Your ref:
Our ref: 21/01265/F
Please ask for: Mrs Lesley Raby
Direct dial: 01553 616818
Direct fax: 01553 616652
E-mail: borough.planning@west-norfolk.gov.uk

Details: **Single storey rear extension and internal works at East Hall Manor 98 Sluice Road Denver Norfolk PE38 0DZ**

Project and address	Sheet	Notes	Client	NASH-WARNER - 007
Extension to East Hall Manor, 98 Sluice Road, Denver, Downham Market	Elevations as proposed	Scale : 1 : 100 Paper size: A3 Date : April 2021 Revisions : -	Nash-Warner

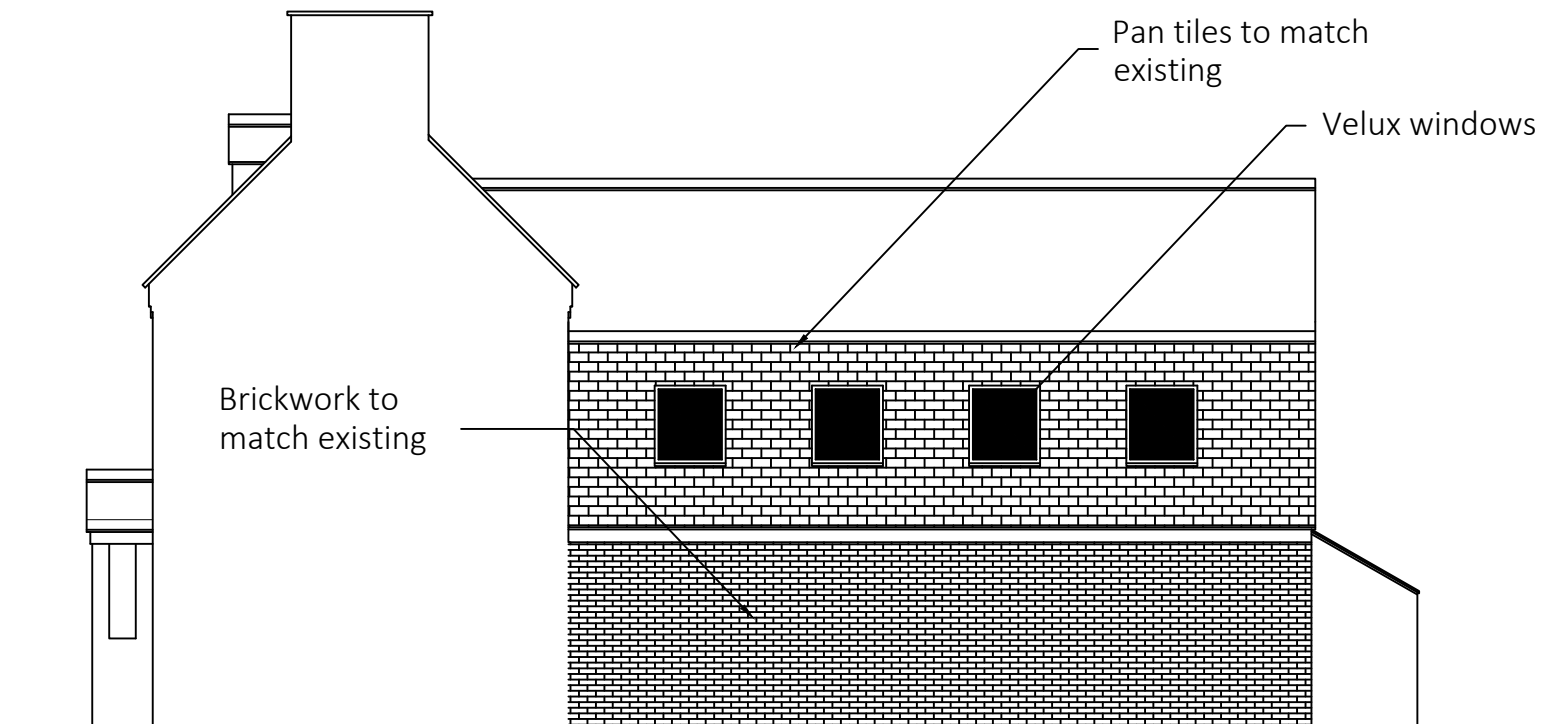
1. Confirm that the finished floor levels will match the existing and that the site levels will remain unchanged.
